**KIRKLEES METROPOLITAN COUNCIL  
INVESTMENT & REGENERATION SERVICE**

Reference No:	<b>2026/70/90266/E</b>
Site Address:	Albion Street, Dewsbury, WF13 2AJ
Description:	Variation of conditions 2 (plans) and 3 (materials) on previous permission 2024/91263 for erection of garage and MOT servicing centre with associated works
Recommending Officer:	Nicole Helliwell

**DECISION – REFUSED**

## **Officer Report**

Proposed Site Plan  
Scale 1:200

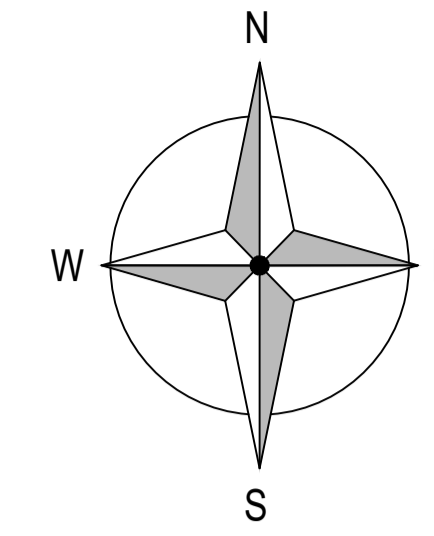
The application seeks to increase the height of the existing boundary walls by 1m -1.5m. Whilst the proposal would alter the external appearance of the site, officers do not consider that the resultant boundary treatment would have a significant visual impact on the character and appearance of the surrounding area and would be acceptable in this regard.

The submitted plans confirm that the existing boundary treatments will be raised as part of the application. It is noted that the wall that abuts the access will be raised by 1m. KC Highways Development Management have reviewed the scheme and have raised no objections in terms of visibility given that the wall already exceeds 1m. Furthermore, no alterations would occur to the access and parking arrangements of the approved scheme. Therefore, the impact on highway safety is still considered acceptable and unchanged since the previously issued decision.

PROJECT NAME			
Albion Street WF13 2AJ			
DRAWING TITLE		DRAWN BY/ CHECKED BY	
Proposed Ground Floor Plan & Elevations		MR/FY	
PHASE	SCALE	SHEET NO.	PROJ.NO.
Section 73 Application	1:50 @ A1	AR-06	C24019

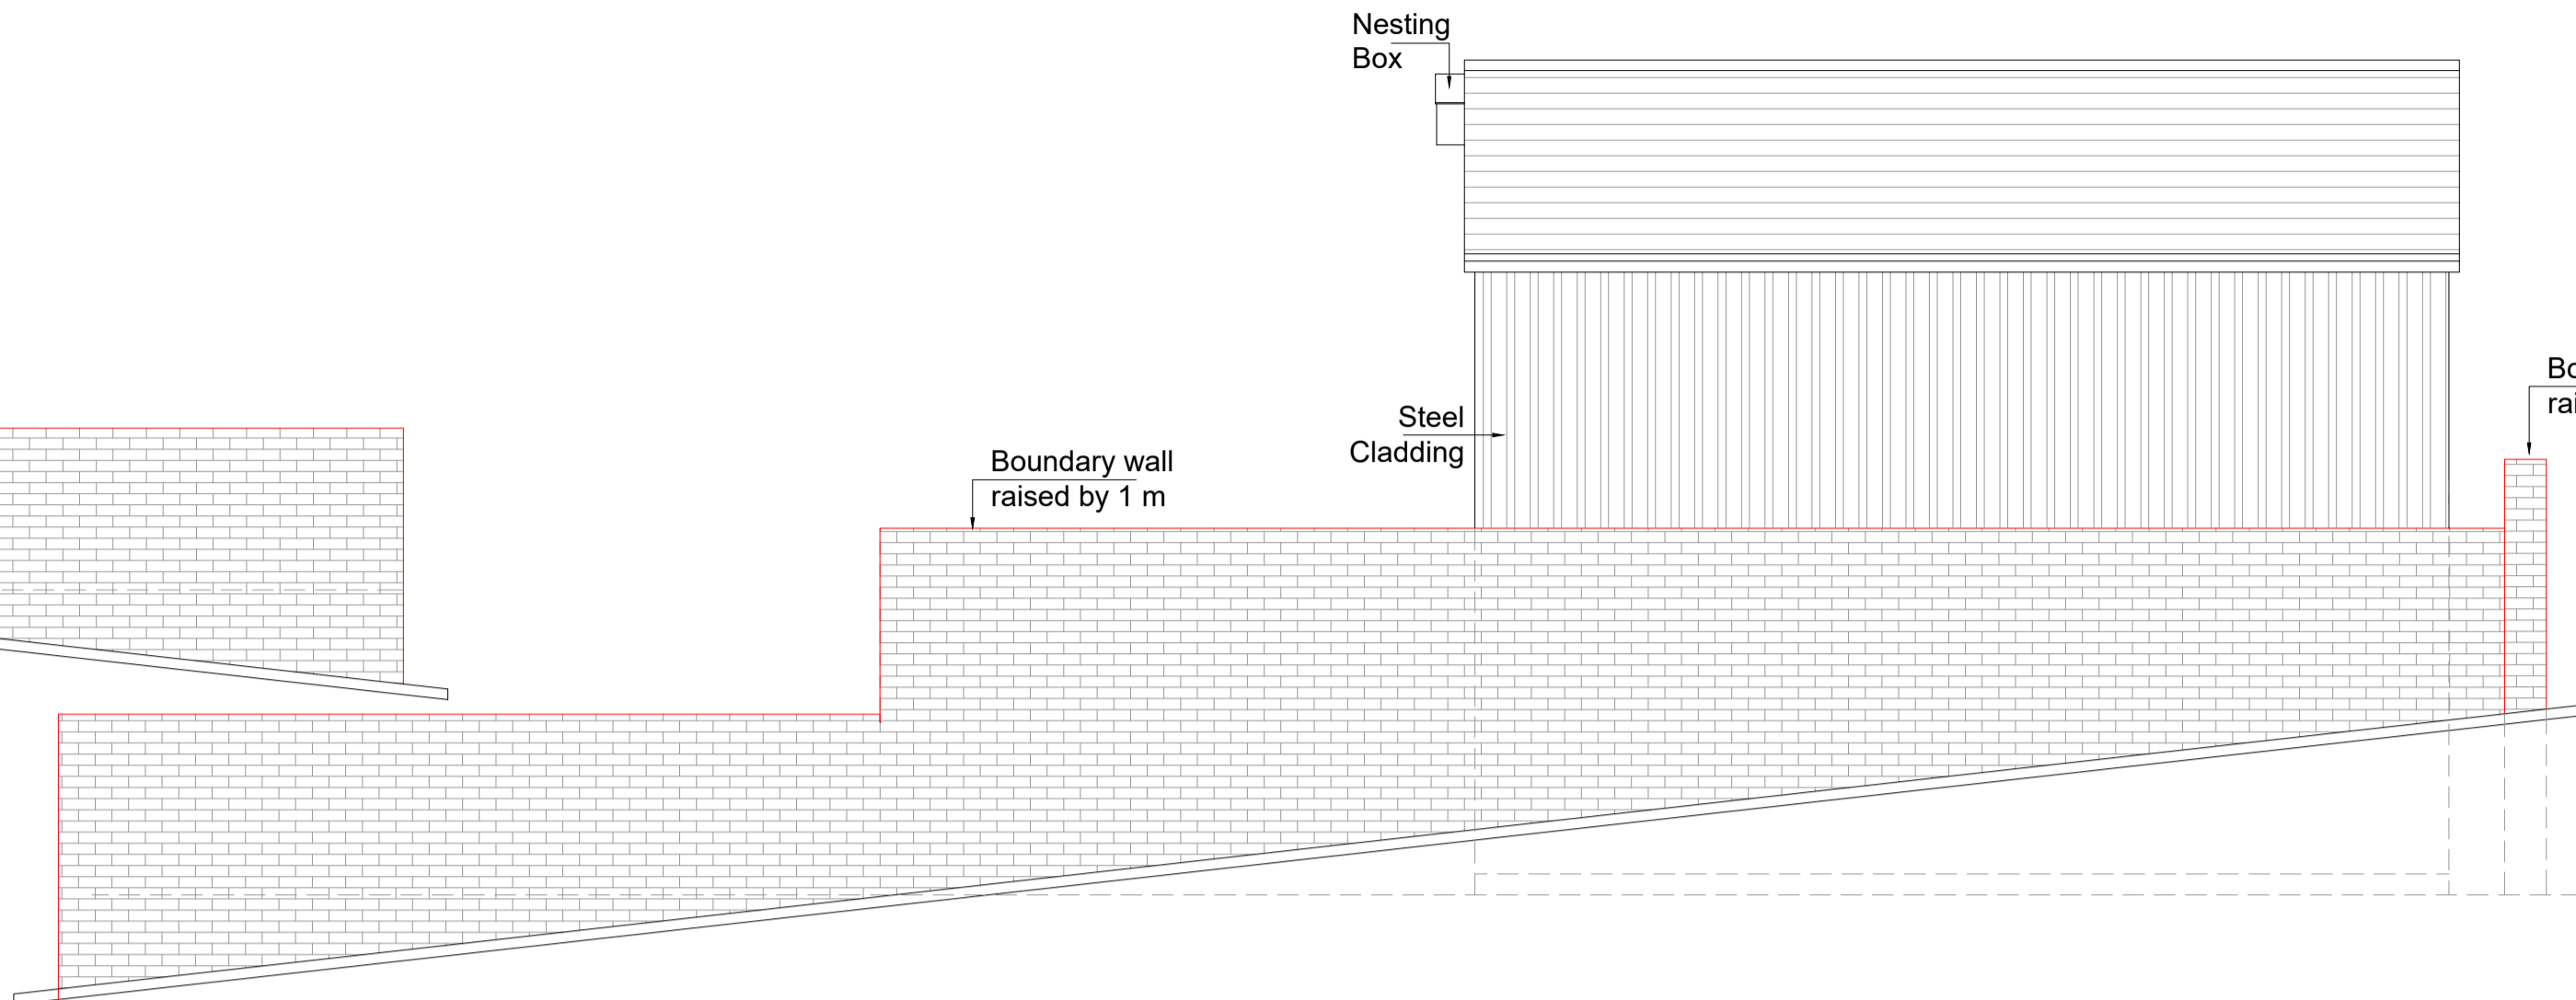
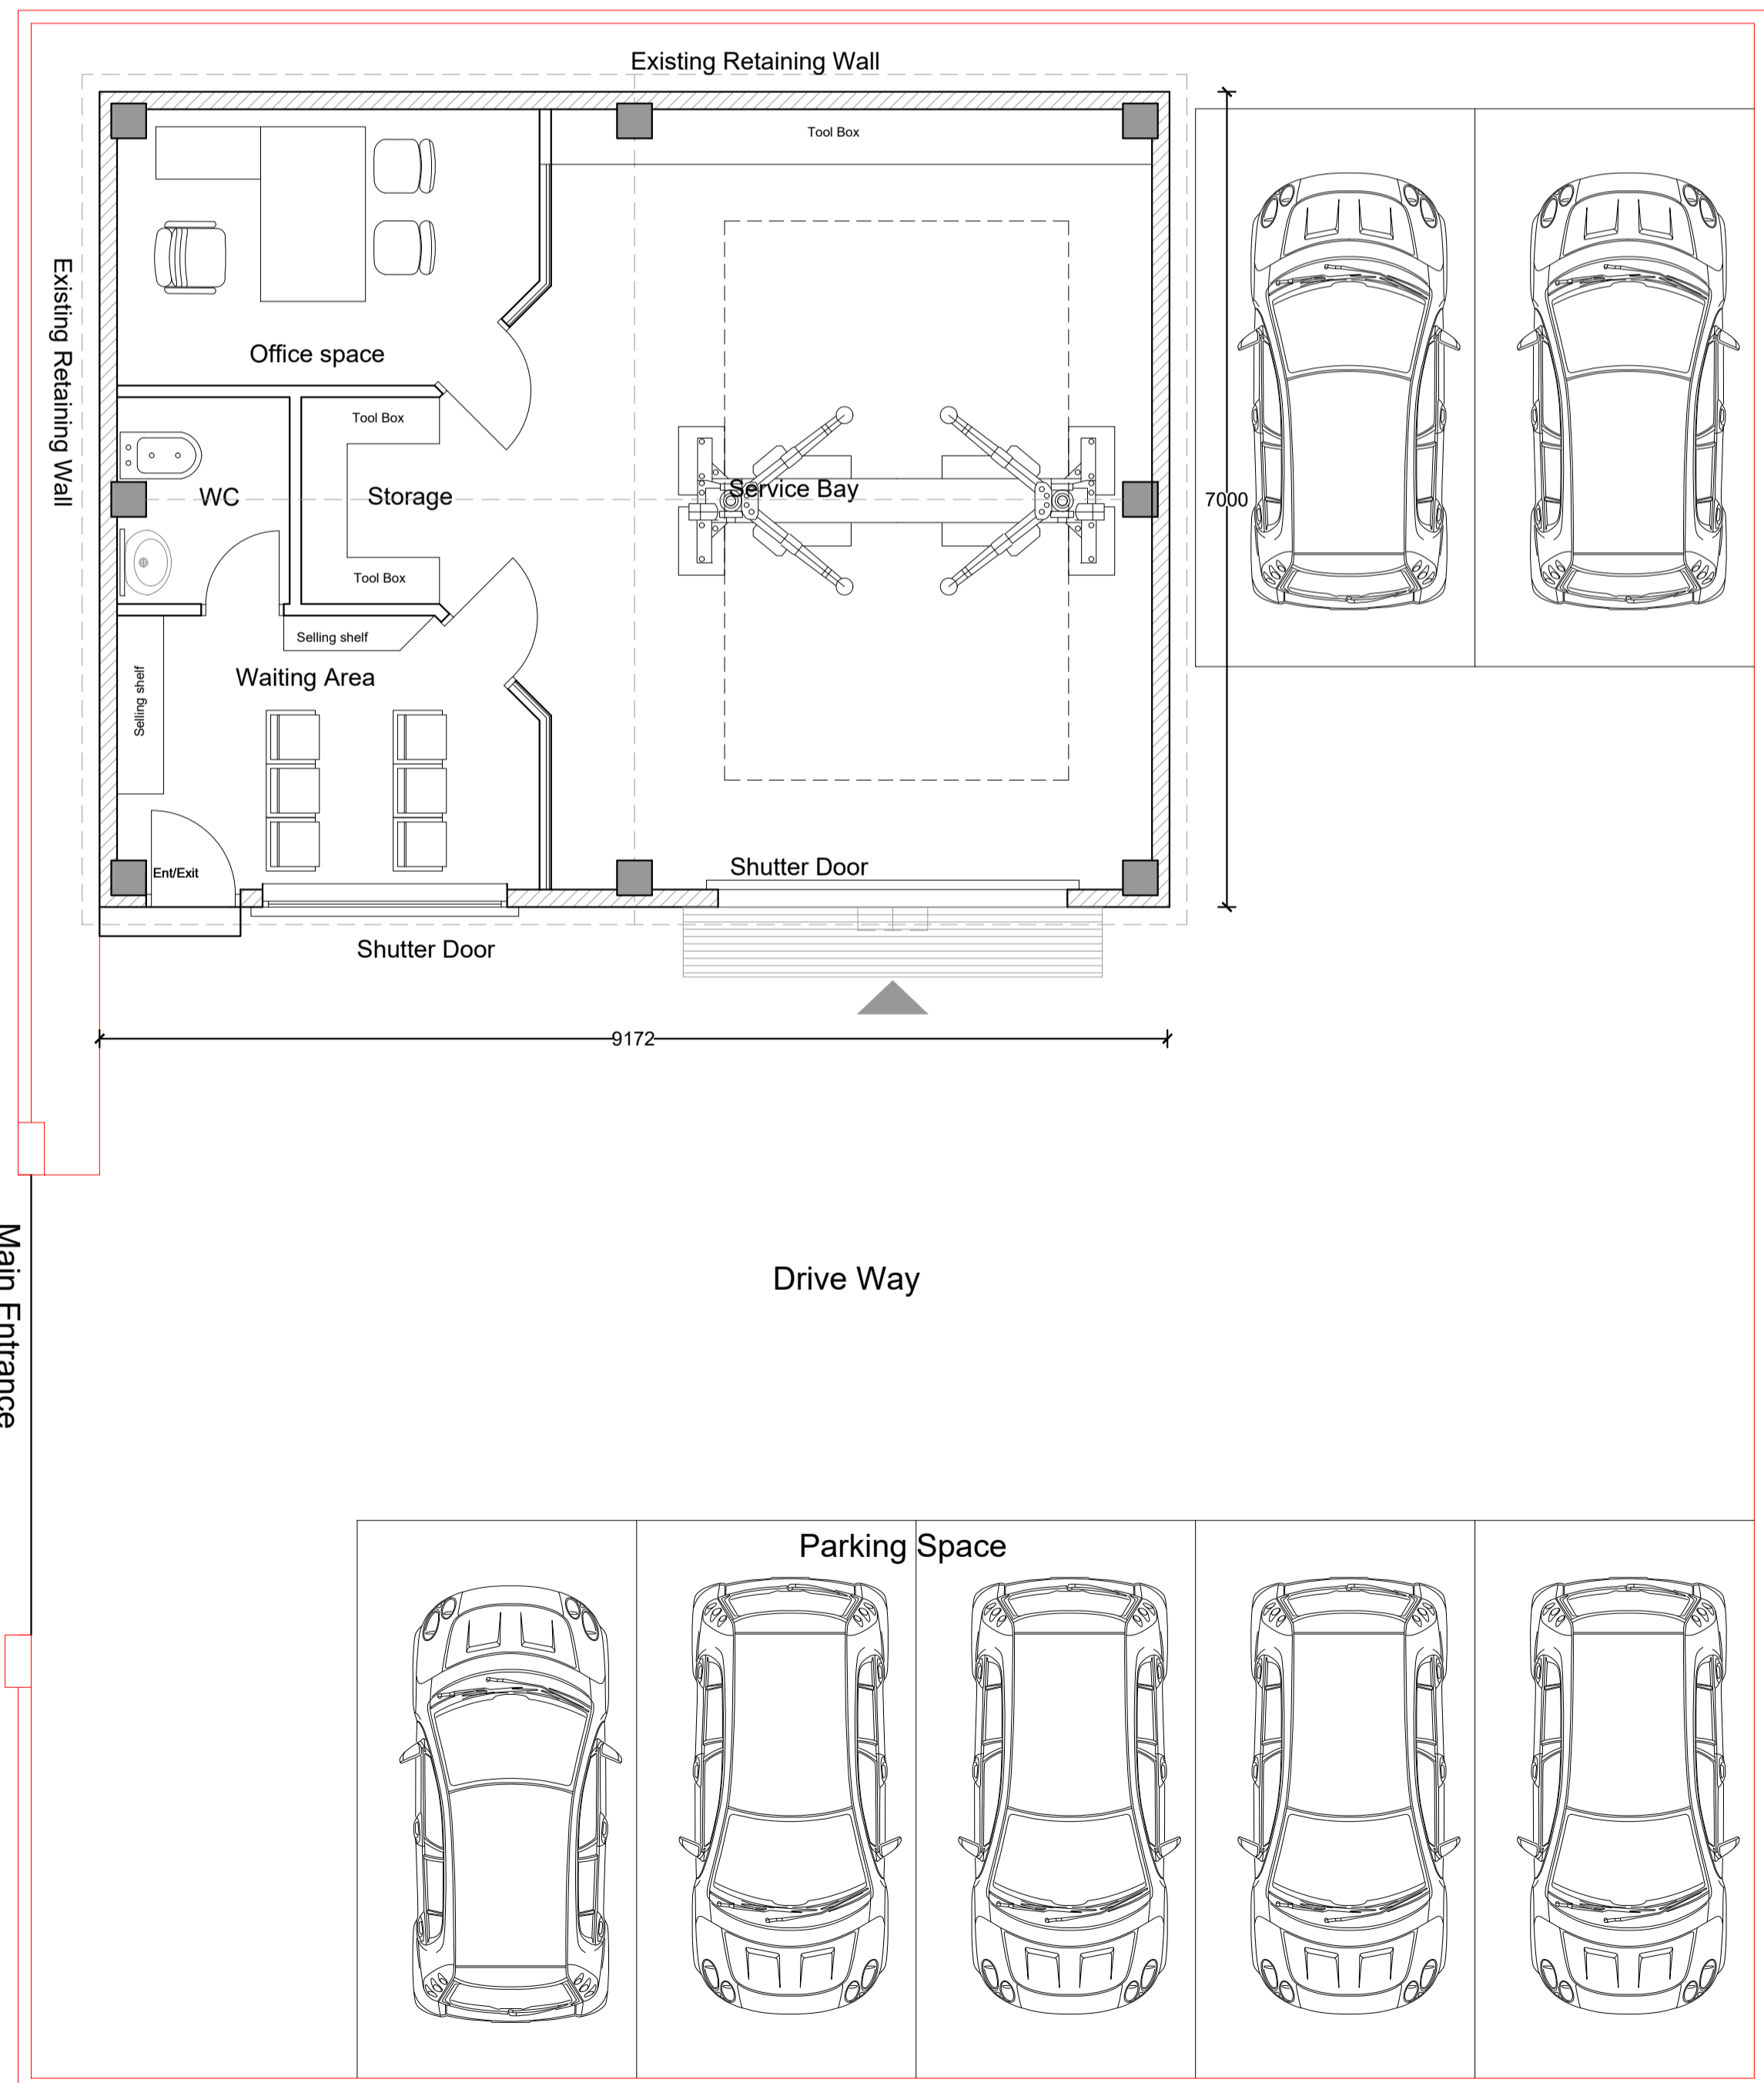
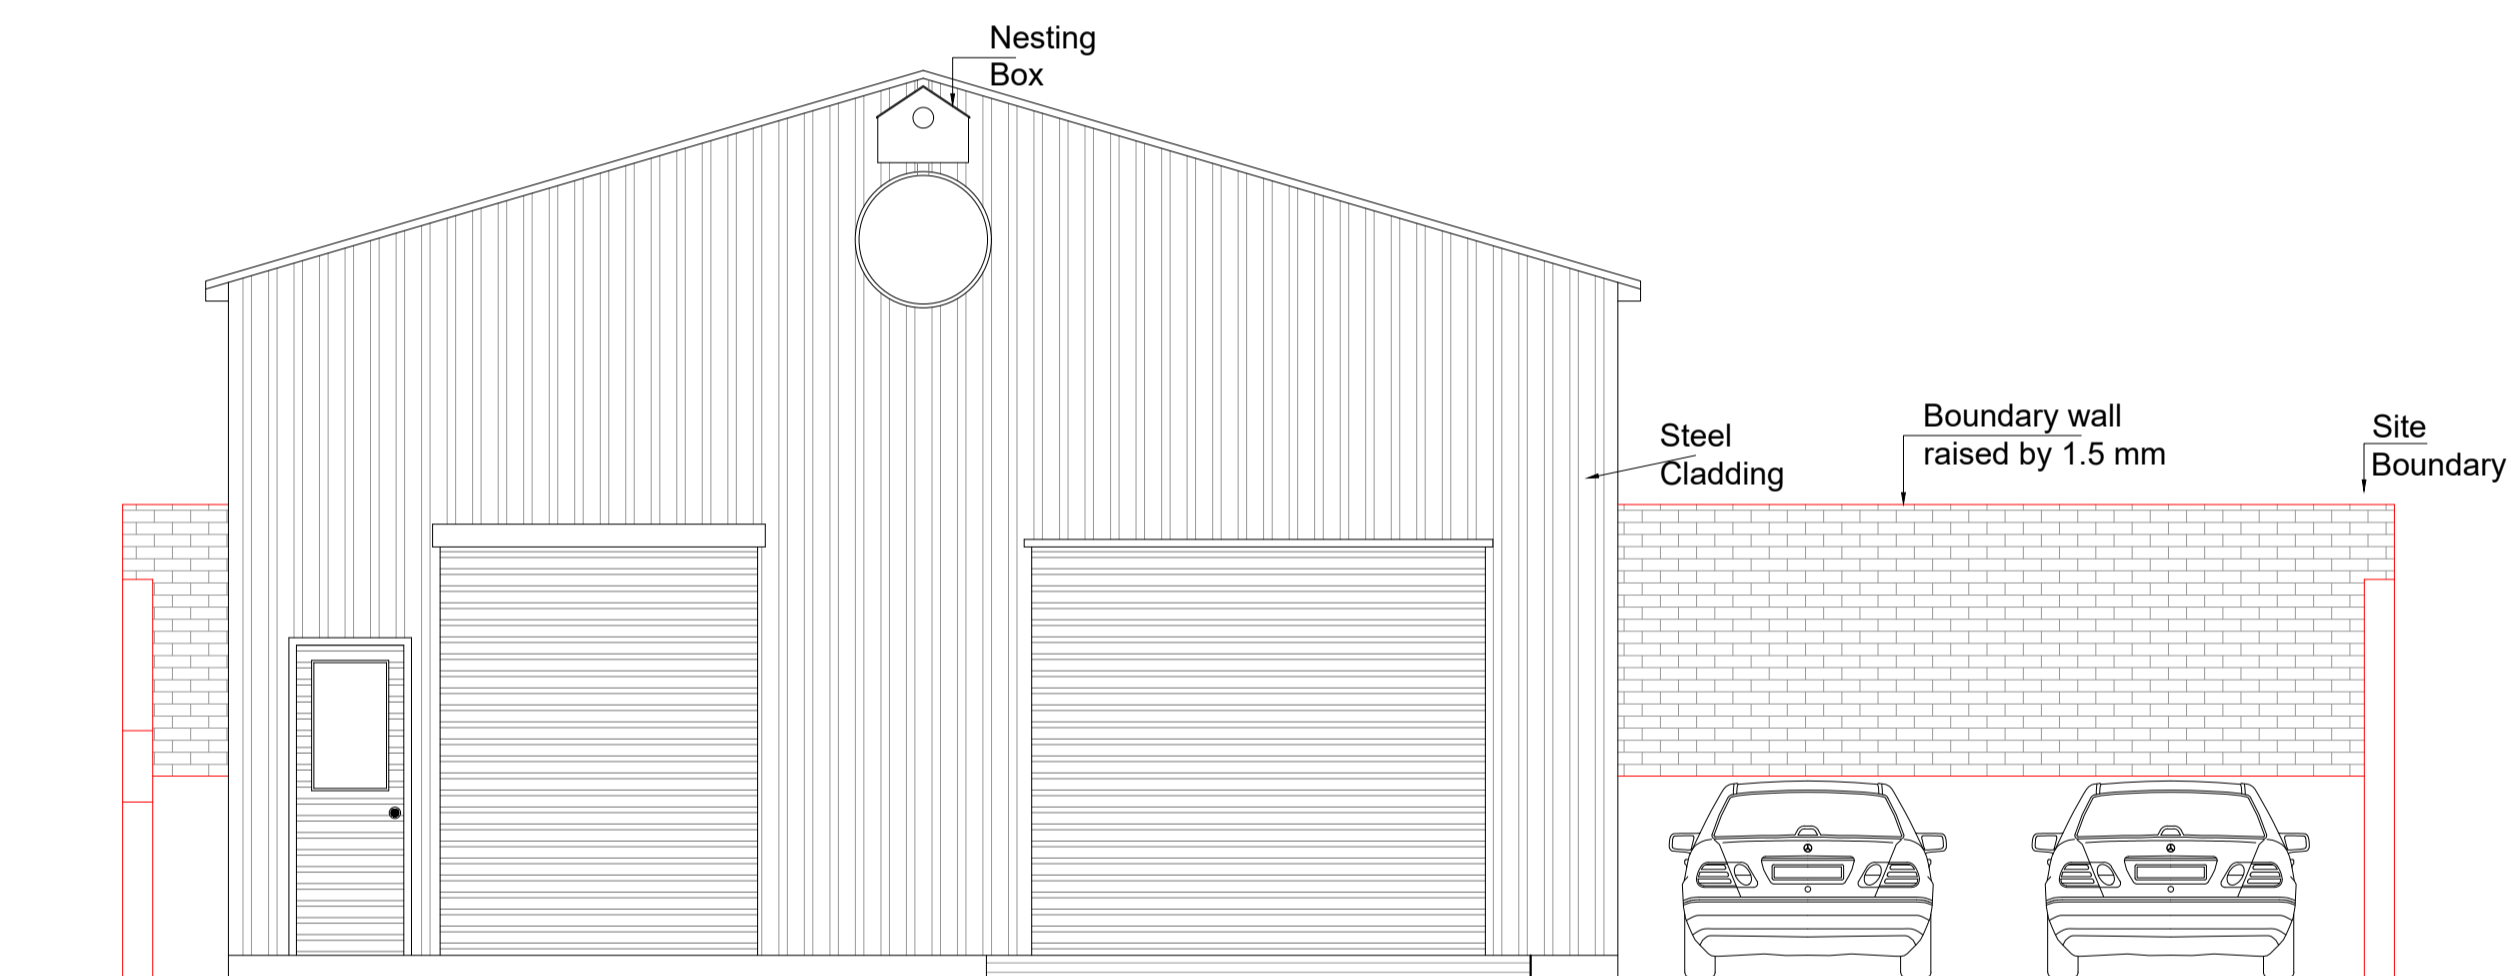
The submitted plans also confirm that the previously approved brickwork for the external walls and slate for the roof of the Garage and MOT servicing centre would be replaced with composite steel cladding. Whilst the increase to the boundary treatment would provide some form of screening, it is noted that the building would project well above the wall and due to the change in materials would appear unduly prominent and highly visible from public vantage points within the Northfields Conservation Area. Furthermore, it is considered that the material palette proposed would be out of keeping with the immediate building group and would fail to preserve or enhance the character of the Northfields Conservation Area.

The proposed variation of condition 3 would detrimentally harm the historic character of the Northfields Conservation Area. The alterations to the material palette would be out of keeping with the immediate building group and would increase the buildings prominence from public vantage points within the Conservation Area. There are no public benefits to outweigh the less than

substantial harm to the setting and character of the Conservation Area. Therefore, to permit the development would be contrary to Policies LP24 and LP35 of the Kirklees Local Plan, and Chapters 12 and 16 of the National Planning Policy Framework.

1. The material palette for the building proposed would be out of keeping with the immediate building group, detracting from public vantage points, detrimental to the historic character of the Northfields Conservation Area for which there is insufficient public benefit to outweigh the less than substantial harm to the setting and character of the Conservation Area contrary to Policies LP24 and LP35 of the Kirklees Local Plan, and Chapters 12 and 16 of the National Planning Policy Framework.
